MARYSVILLE
PUBLIC WORKS

MEMORANDUM

SUBJECT: PA 22-008 – Undi Commerce Park

I have reviewed the Undi Commerce Park TIA for the proposed Warehouse/Office on the east side of State Avenue south of 152nd St NE and have the following comments:

MIC SOUTH - EXISTING

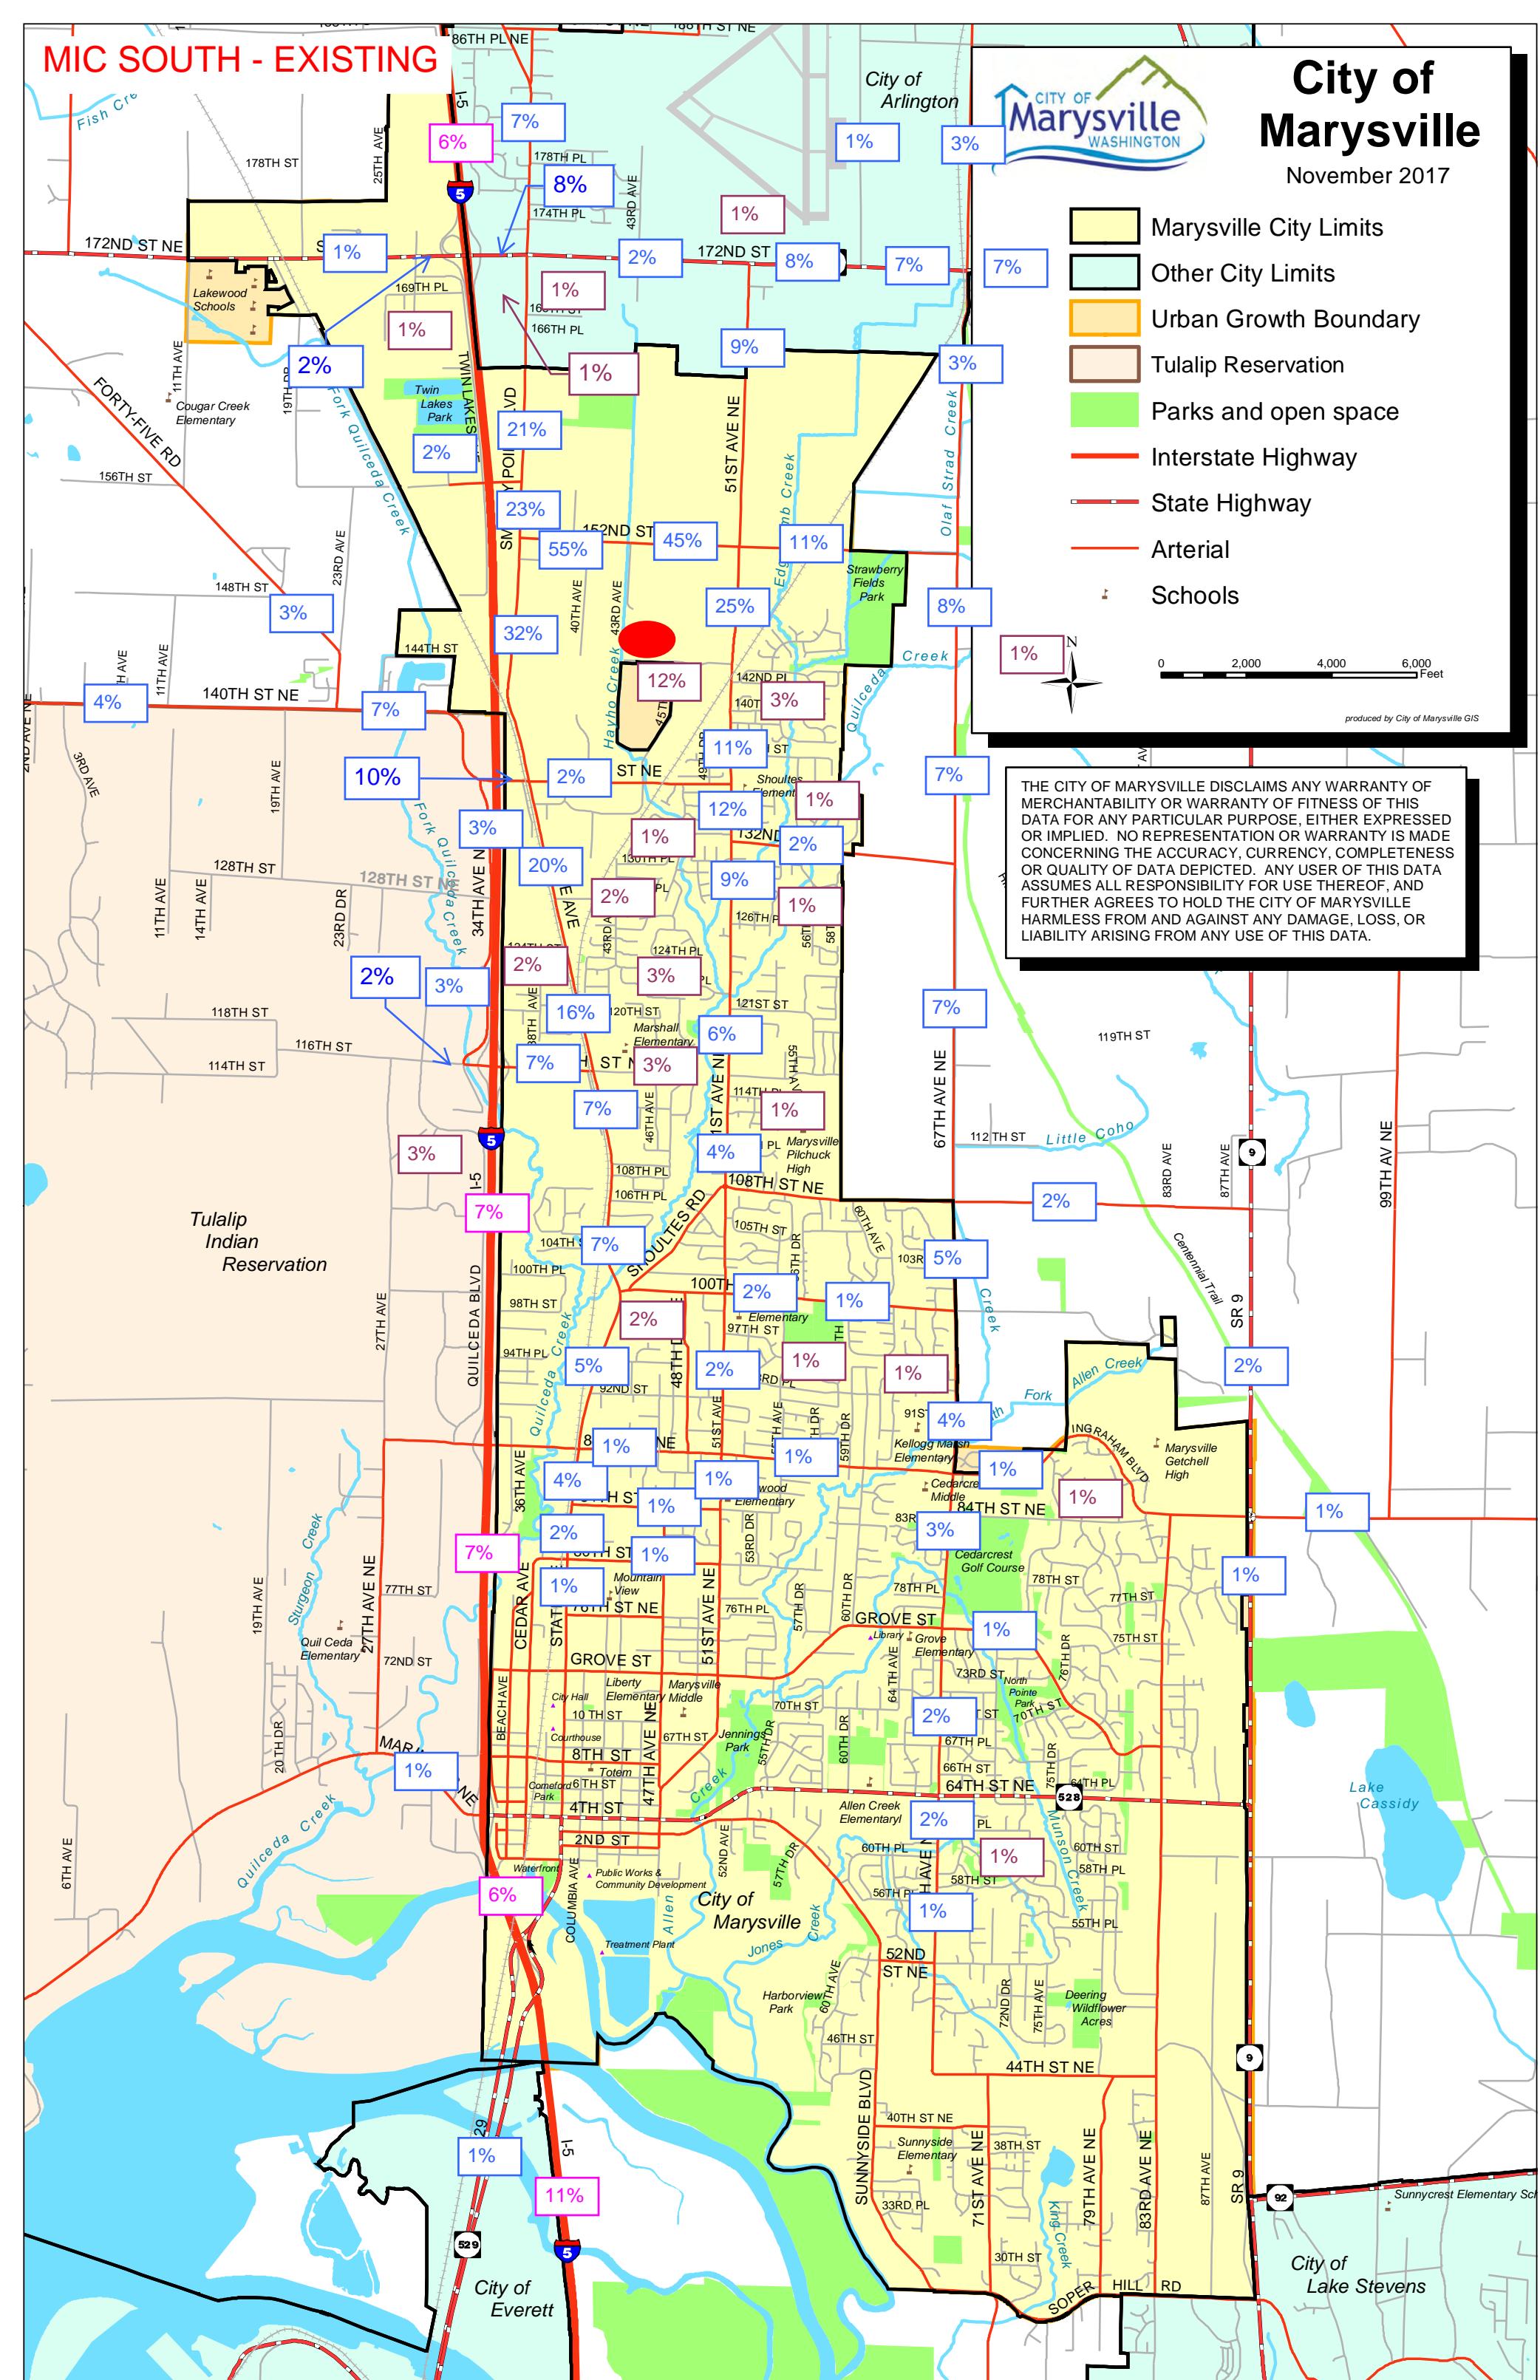
- b. TIA should follow City guidelines to be provided.
 - i. Trip Distribution:
 1. Trip distributions for Existing and Horizon year shall be based upon corresponding roadway network for each.

- a. Provide Trip Distribution for:
 - i. Opening Year (Existing Network)
 - ii. Horizon Year
 - c. Intersection Analysis:
 - i. Horizon year analysis should assume TIF calculation projects are constructed.

MIC SOUTH - HORIZON

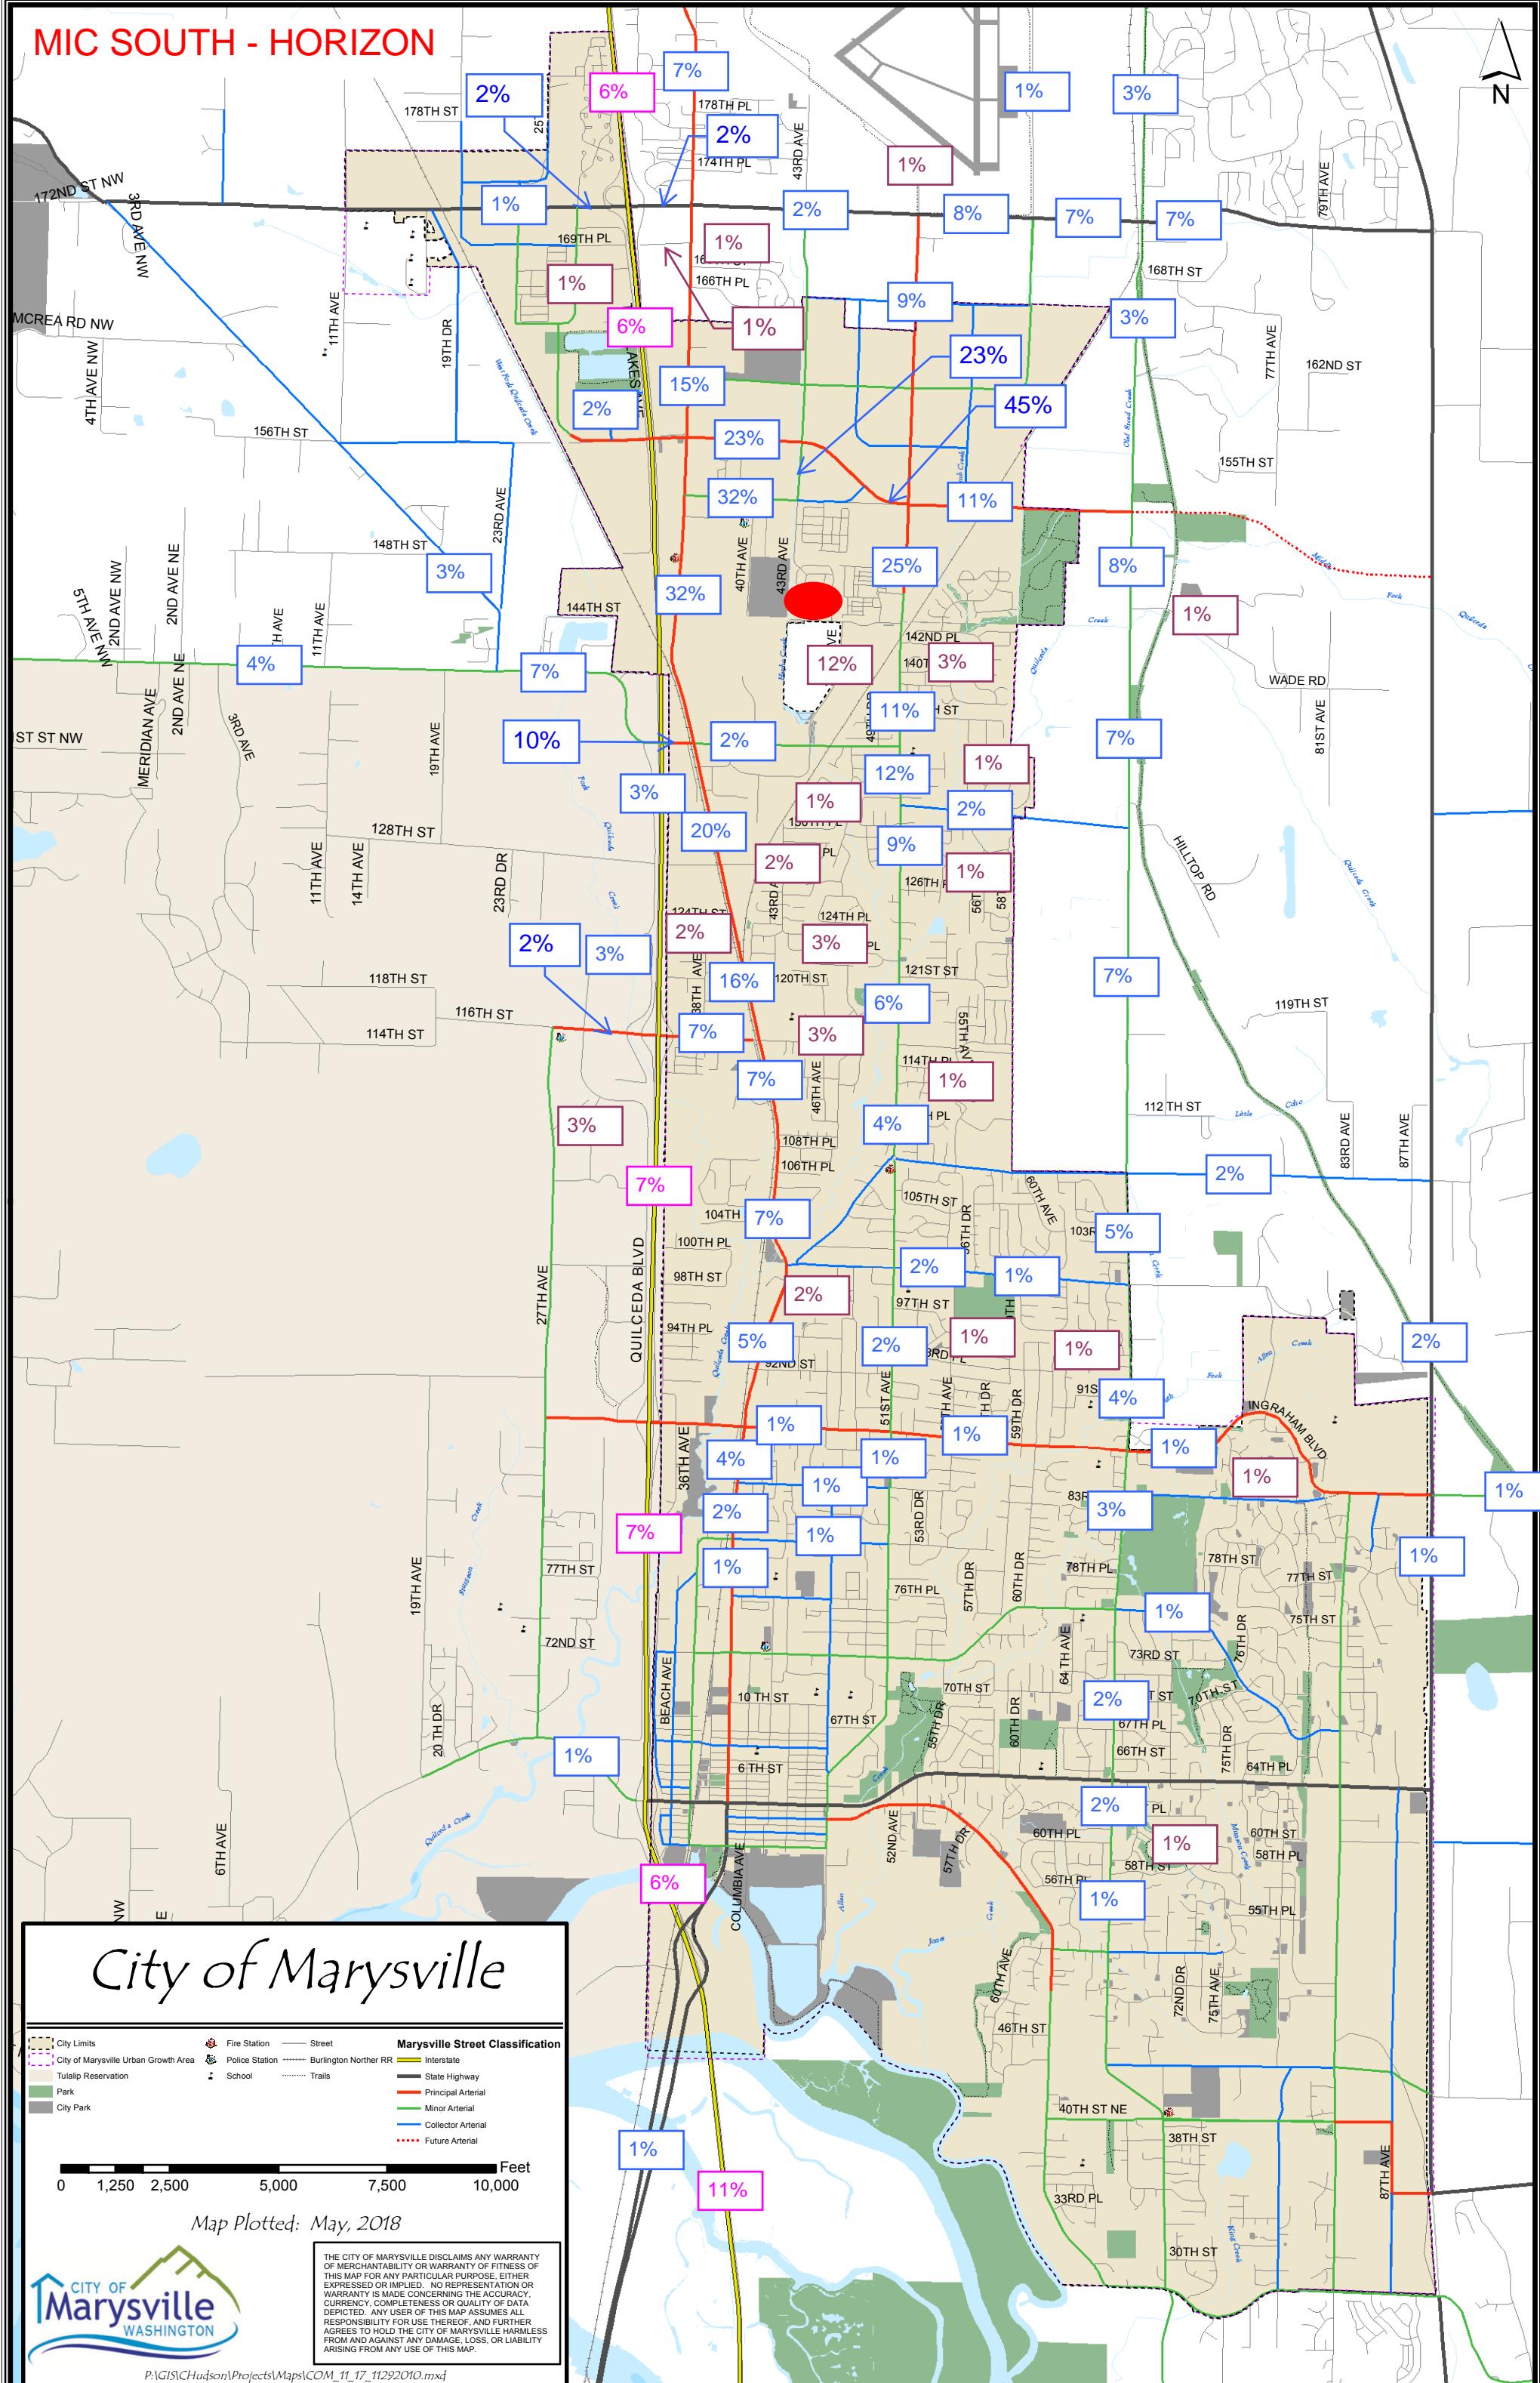
1. 156th ST NE & 51st Ave NE:
 - a. Assumed signalized intersection with:
 - i. EB/WB approaches of LT lane, 2 x Thru Lanes & RT Lane
 - ii. NB/SB approaches of LT lane, Thru lane and RT lane.

2. State Ave & 116th ST NE:
 - a. Assume additional lanes per TIF are constructed including:
 - i. Additional WB Thru
 - ii. Extended EBRT lane storage length.

- b. Assume EB/WB split phasing is removed.
 3. 51st Ave NE & 132nd ST NE:
 - a. Assume 51st Ave NE widening is complete including SBLT at all-way stop controlled intersection:
